ENG-CDR18006-GEC-V1-Redlines.pdf Markup Summary

TYPICAL STREET SECTIONS

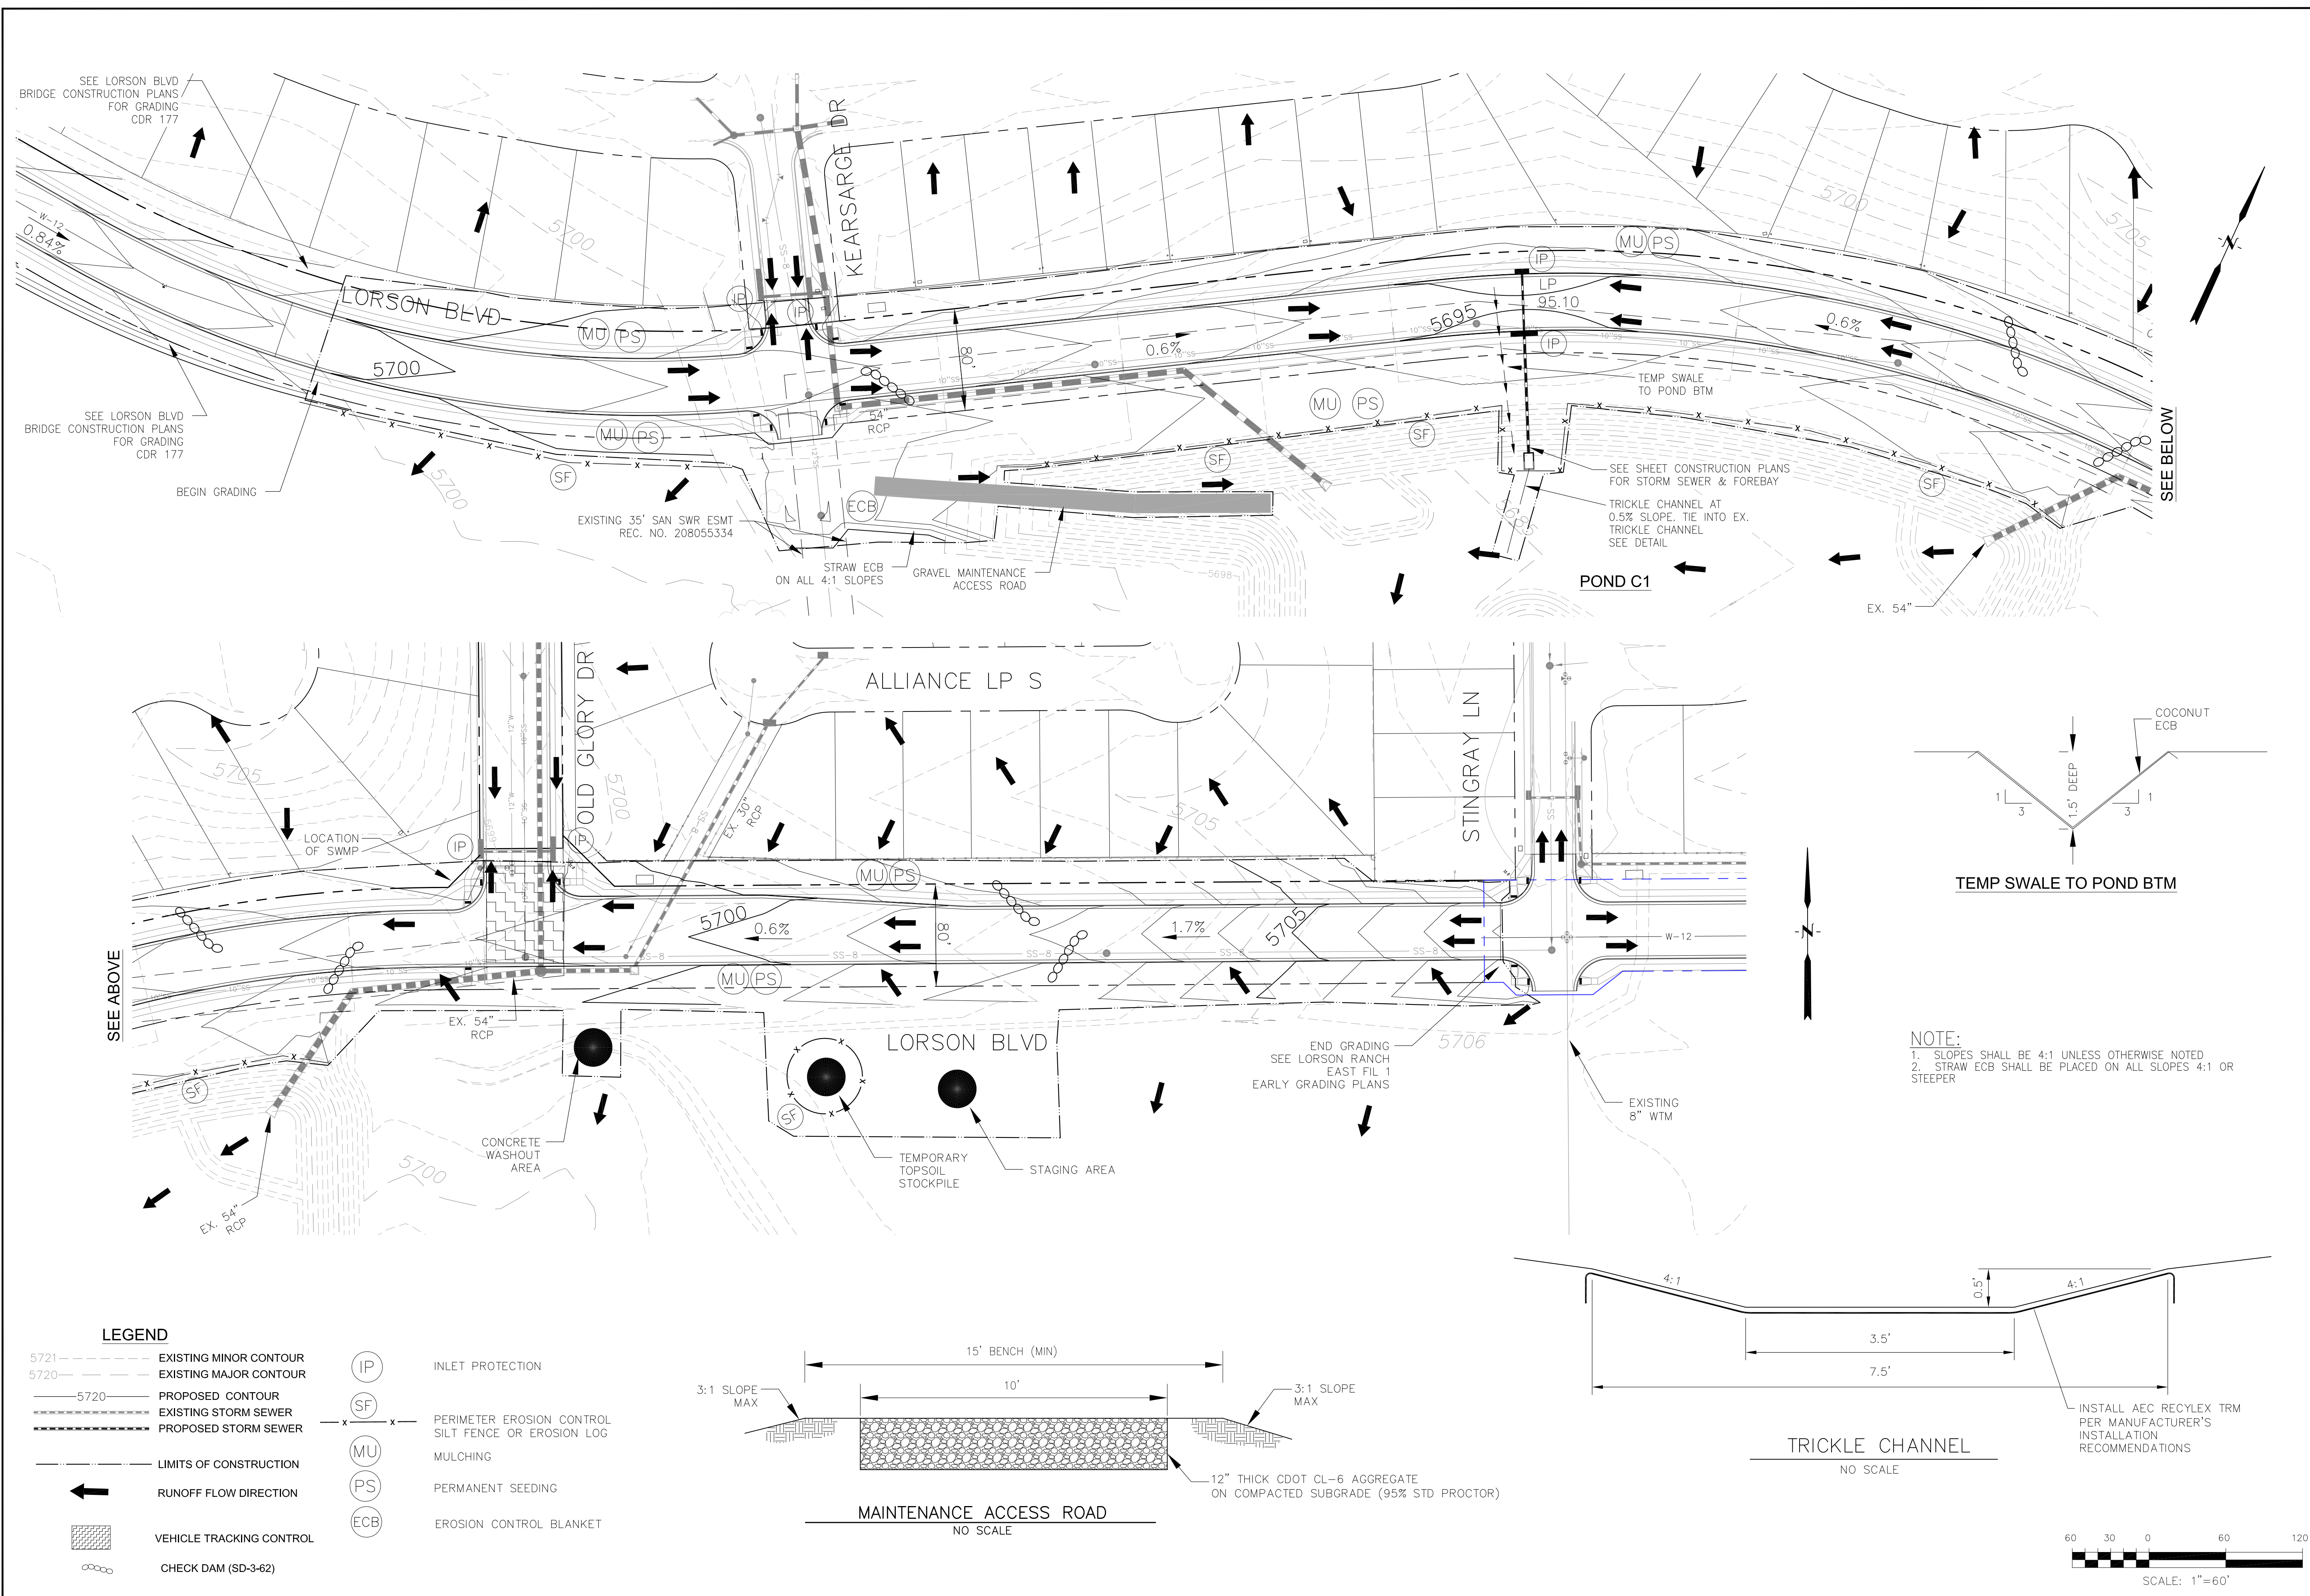
Is this to be a stabilized access surface? Label if so.

ECB, PS?

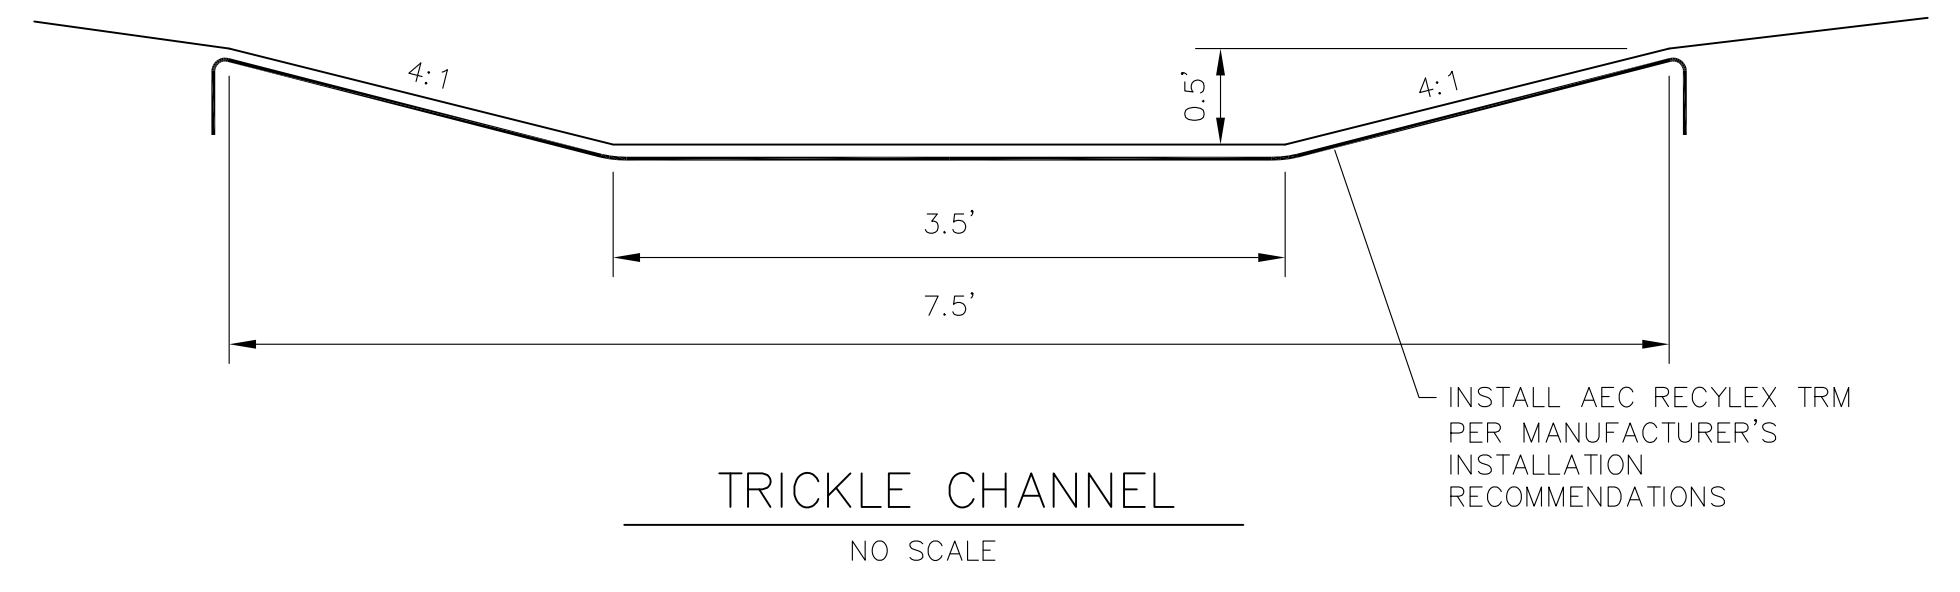
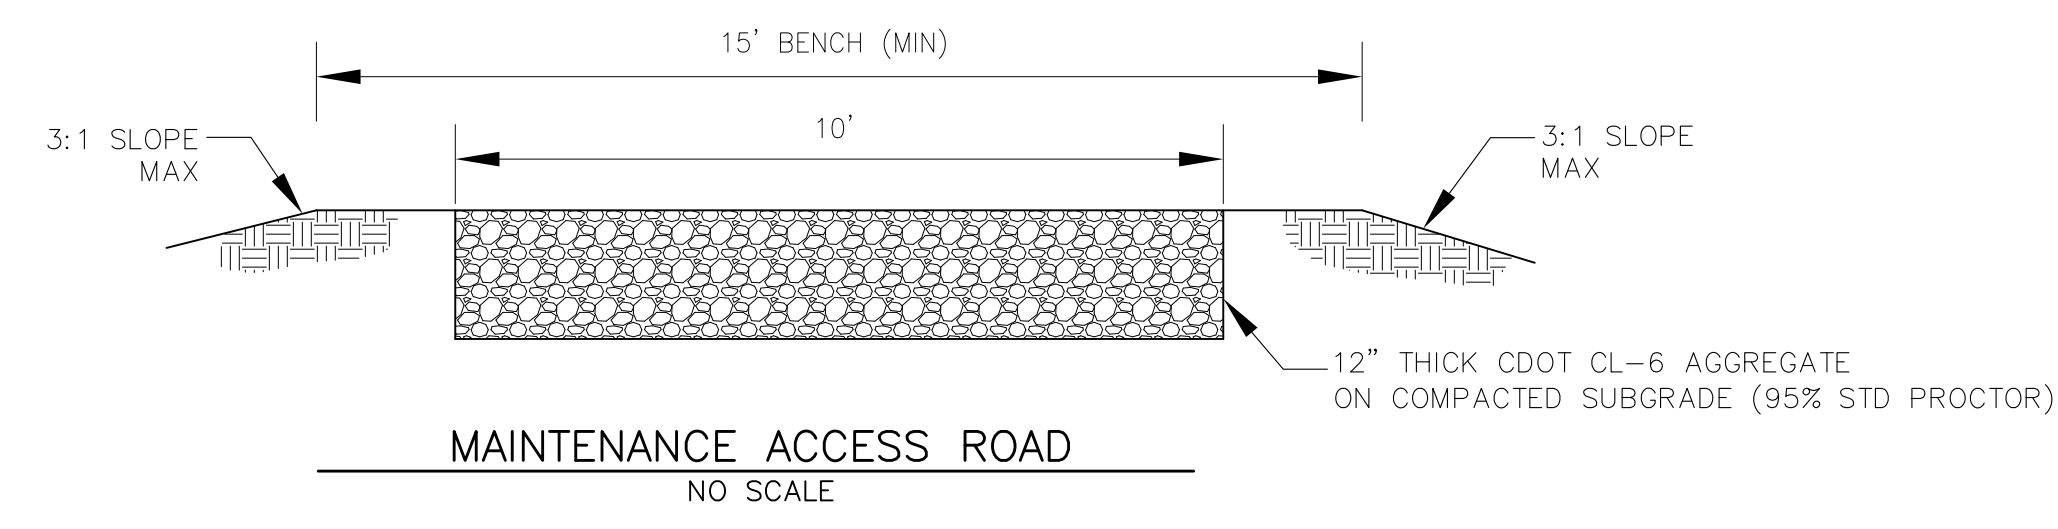
Show forebay grading. Are wingwalls needed?

Label 100-year floodplain

Label EF JCC

Shouldn't limits of construction include this?
